CITY OF ALBUQUERQUE

Re: Aztec Special Education Facility
Request for Certificate of Occupancy- Transportation Development
Architect's Stamp dated 09-22-15 (H20-D033)
Certification dated 01-12-17

ASI-042

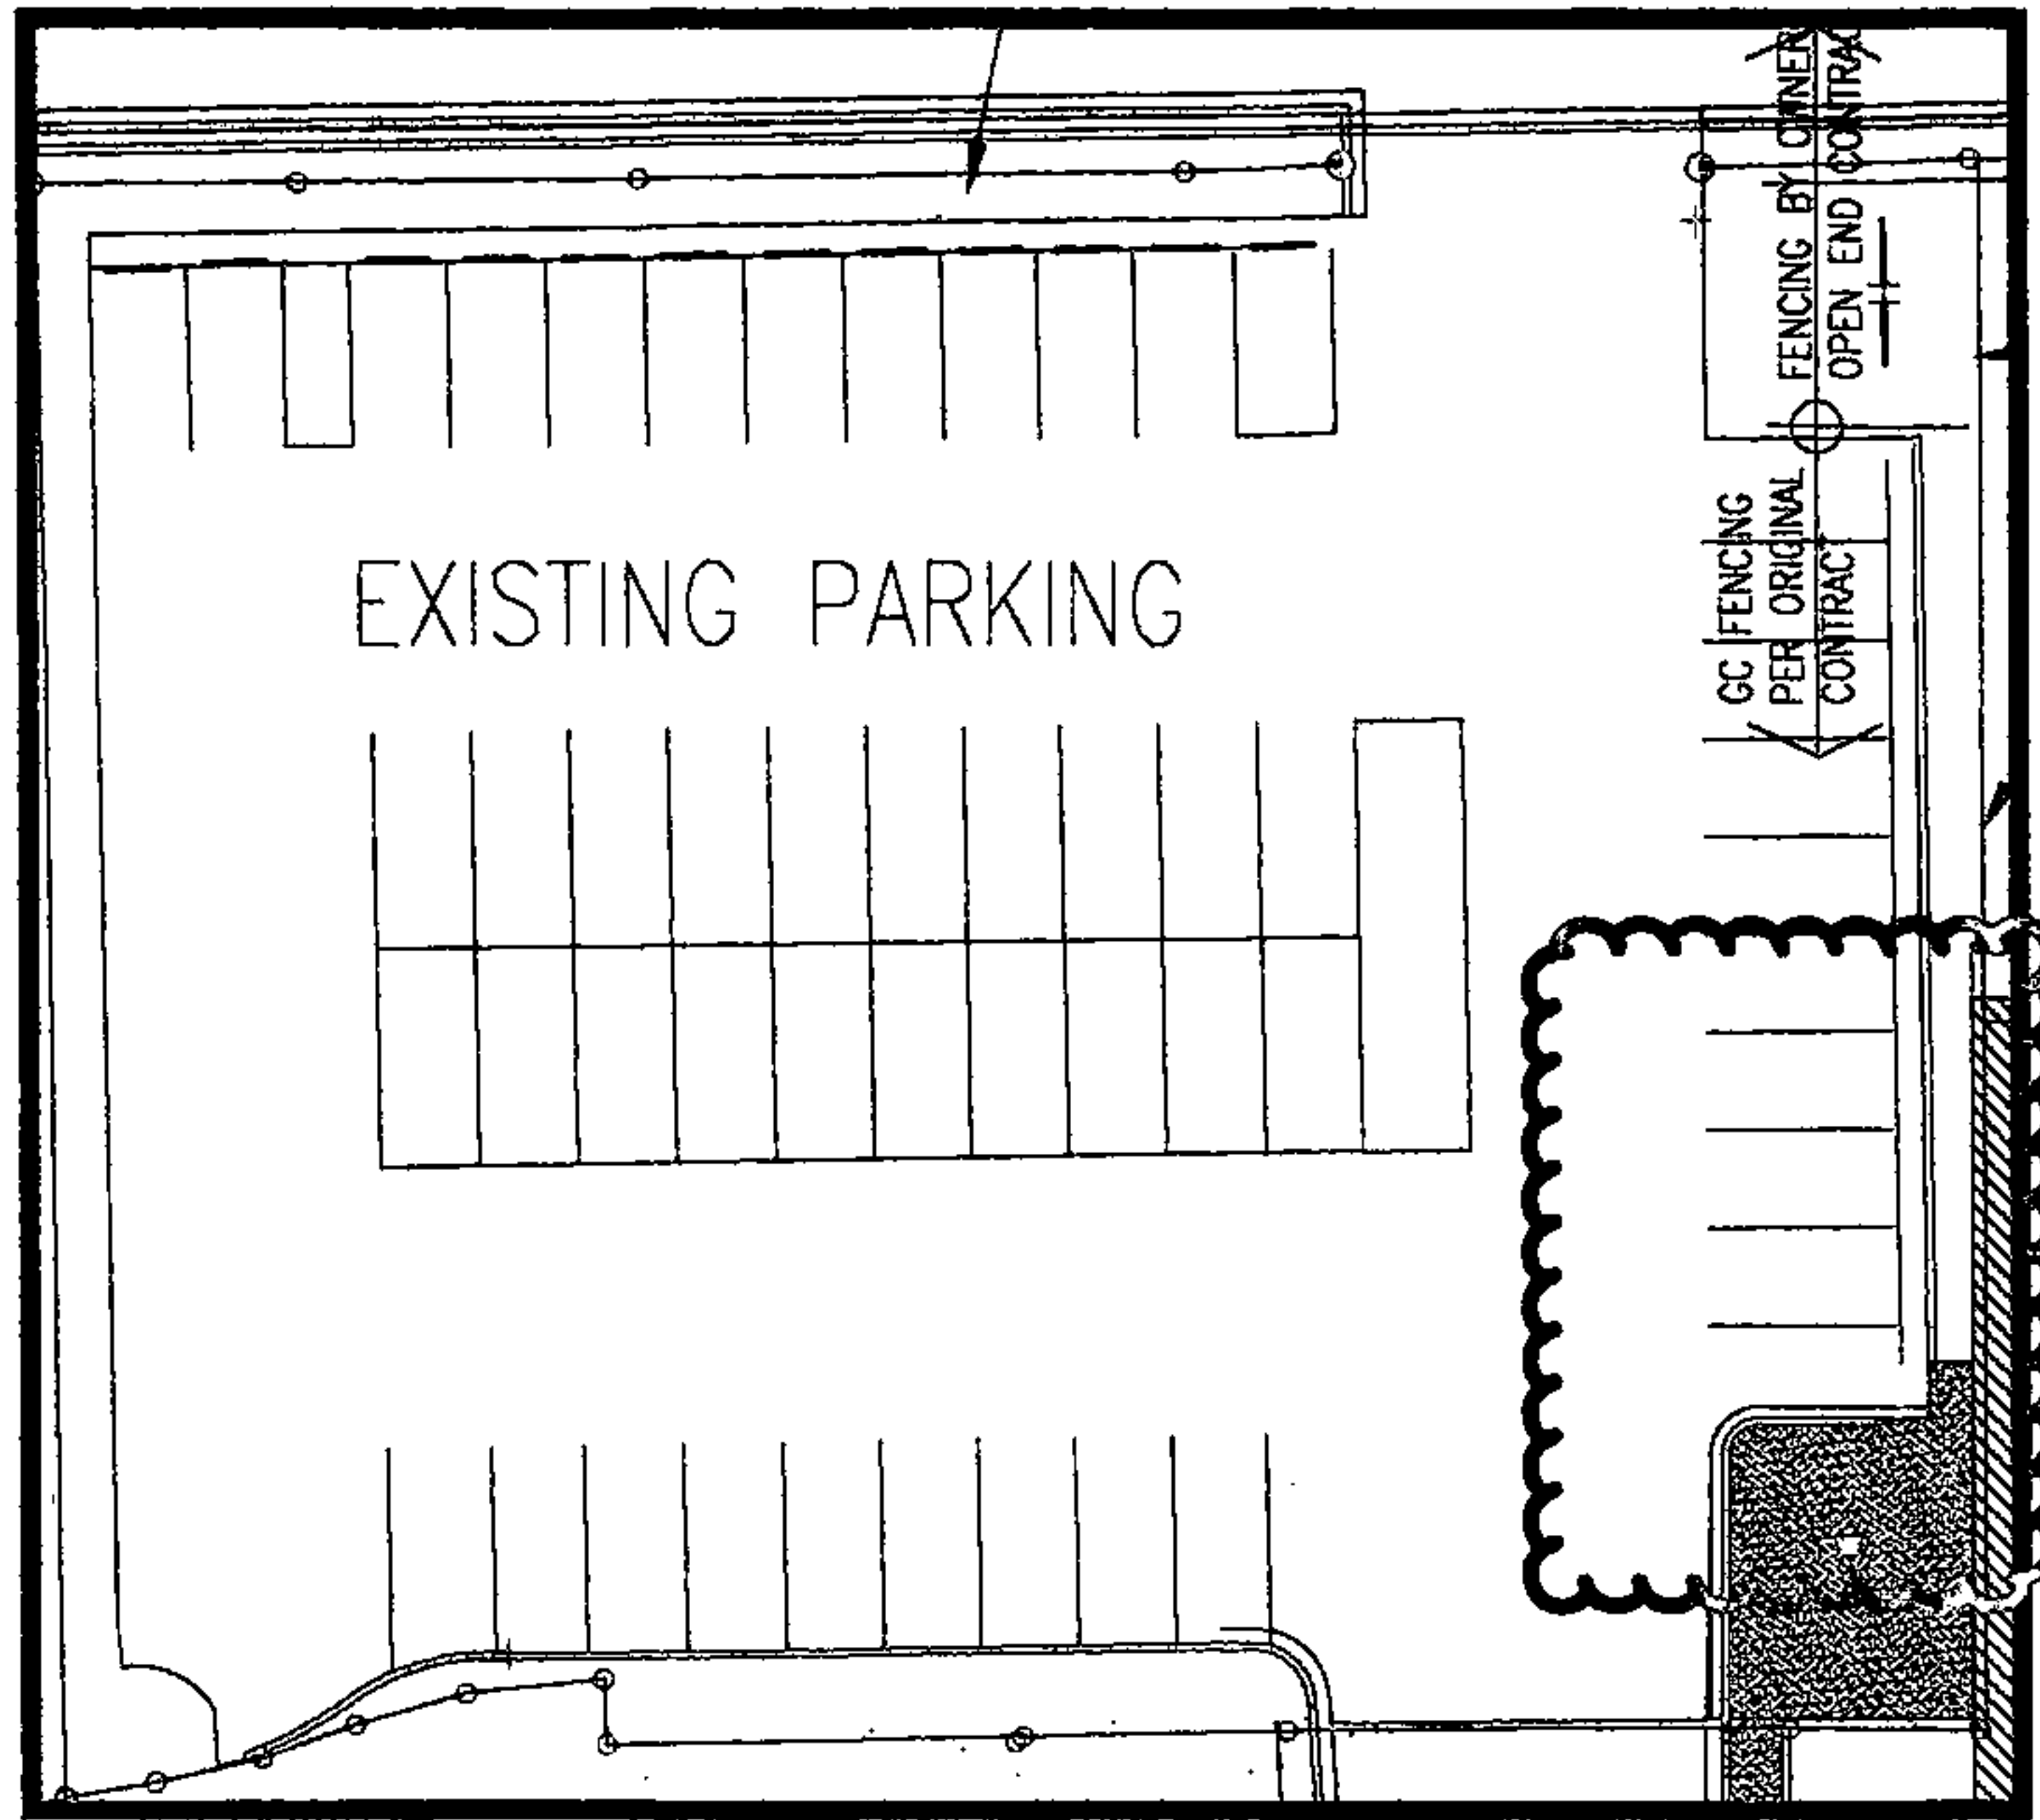
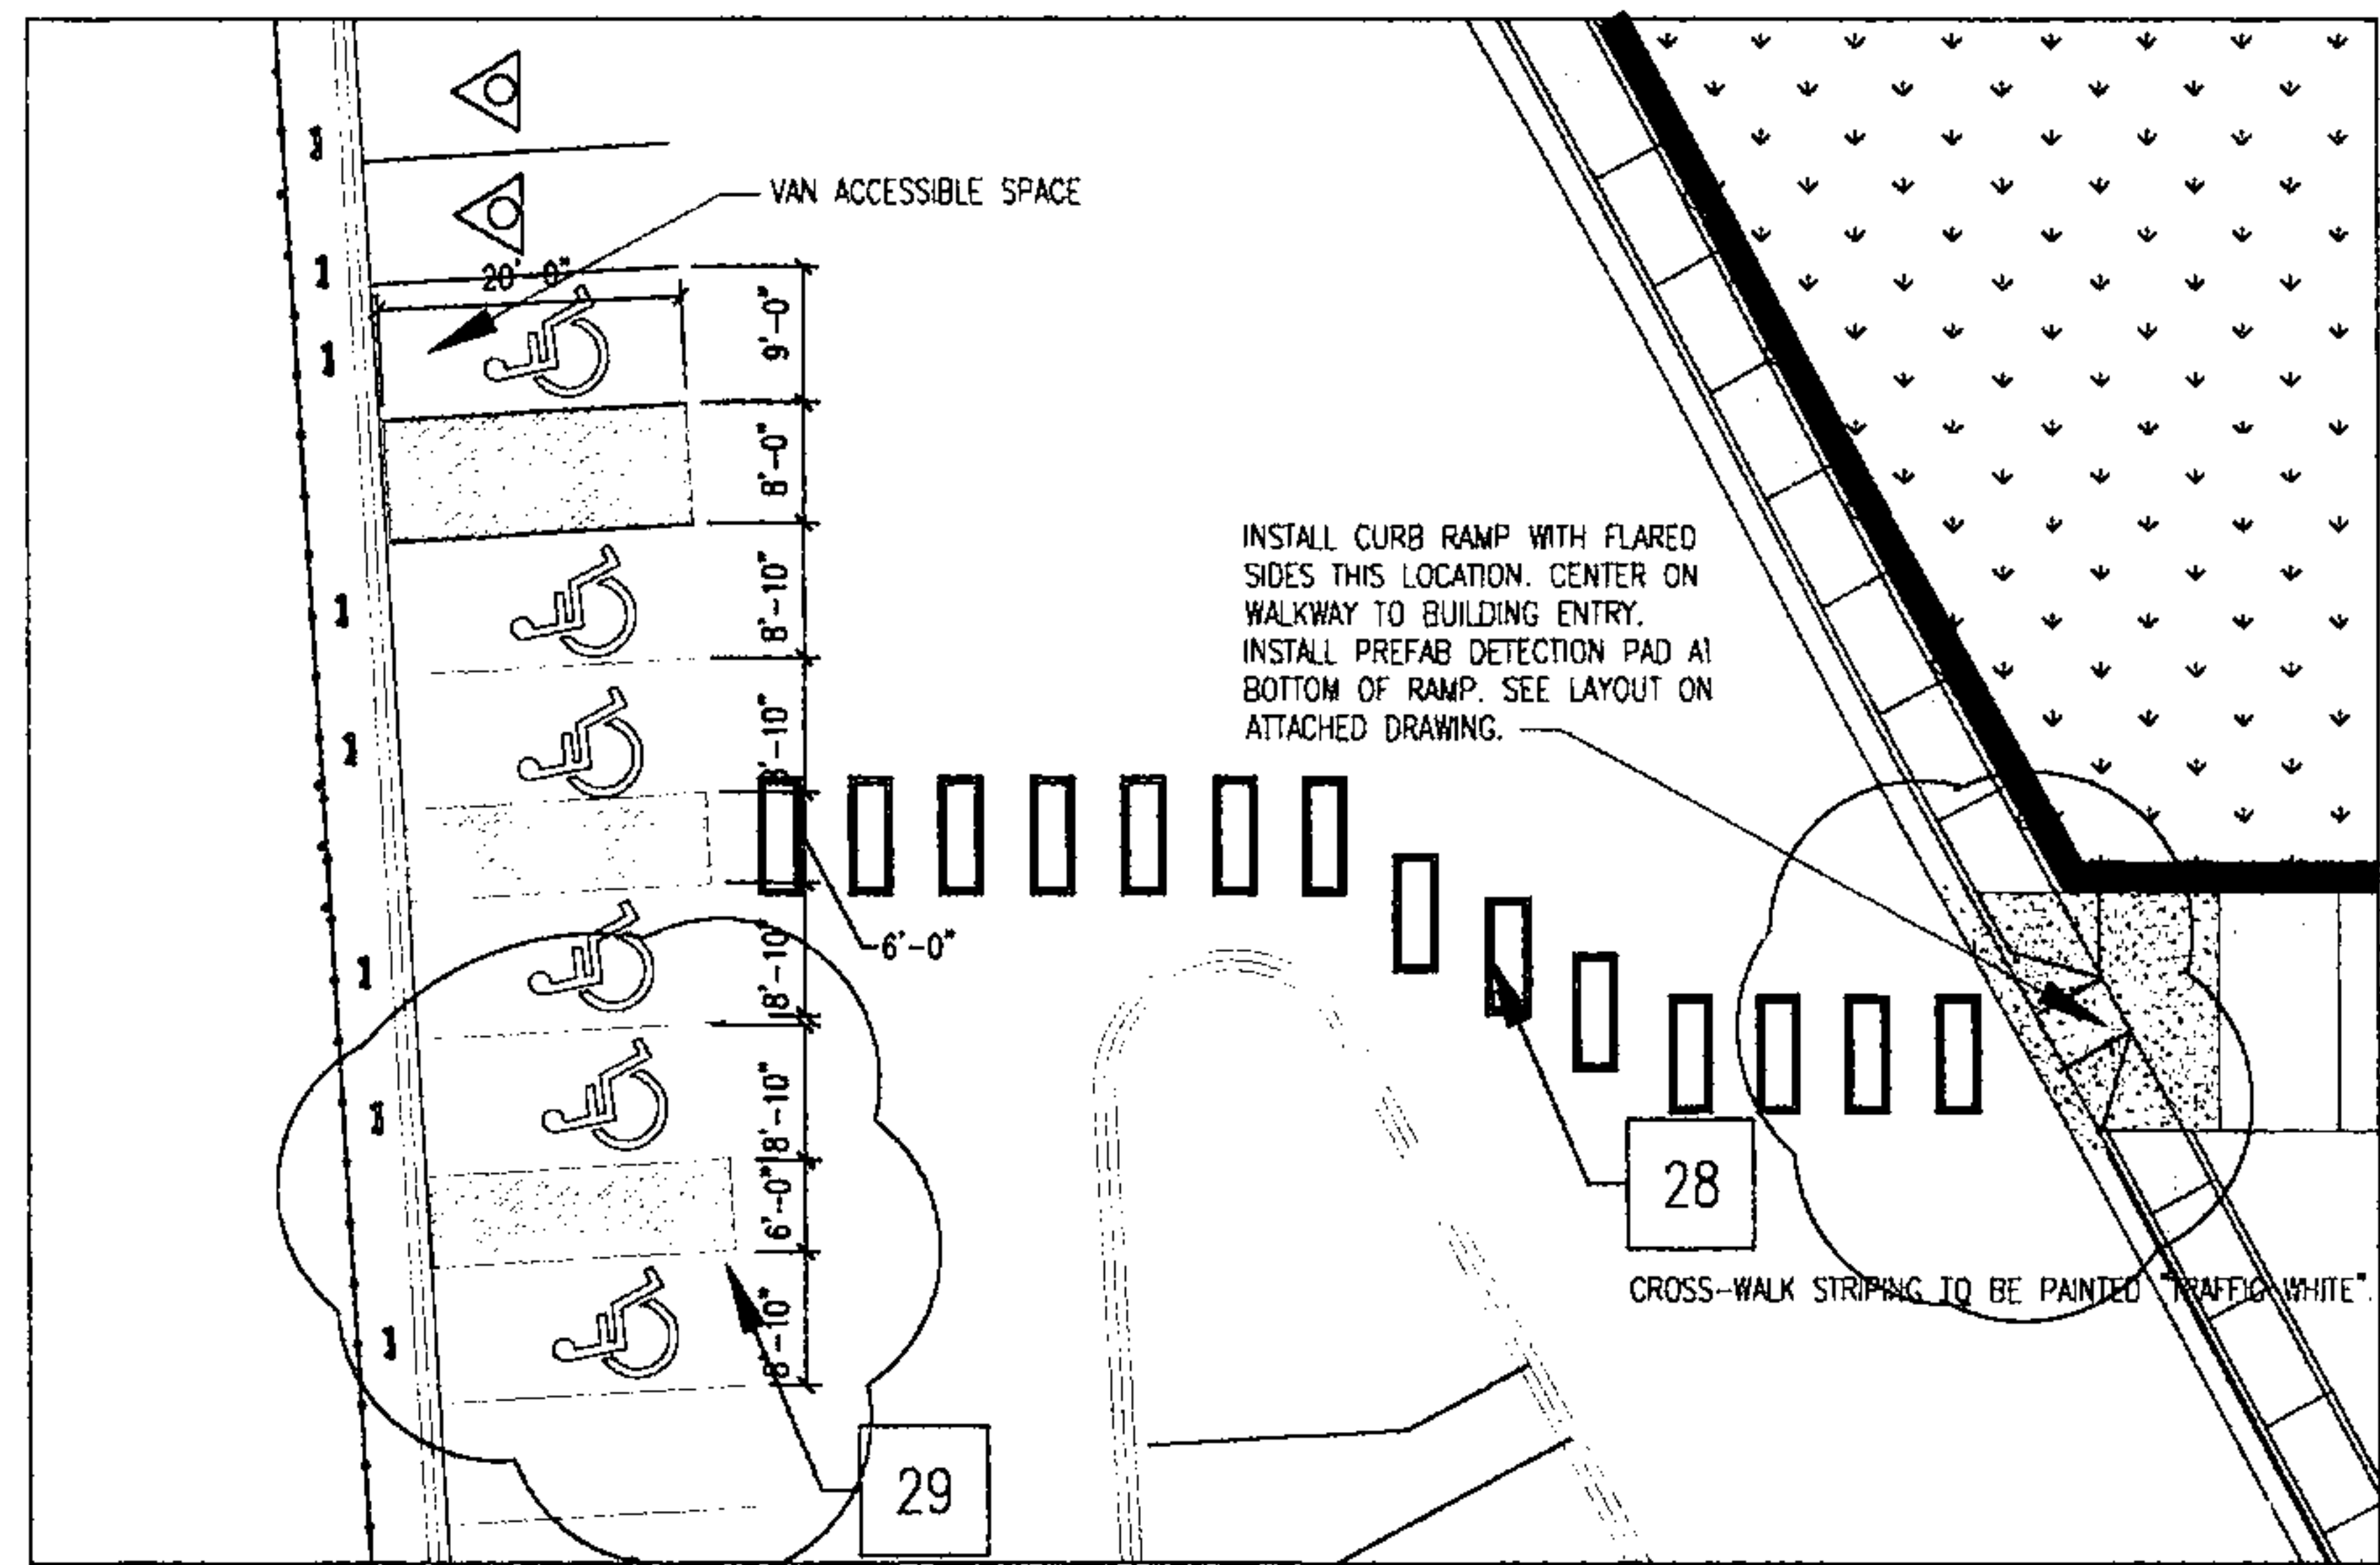
- The site had construction equipment, material, and debris throughout the parking lot. The site should be safe and ready for use by the general public at CO.
- The ADA access ramp on exhibit ASI-042 did not have the prefab detection pad or detectable warning surface as indicated on the plans.
- Motorcycle space should be labeled.
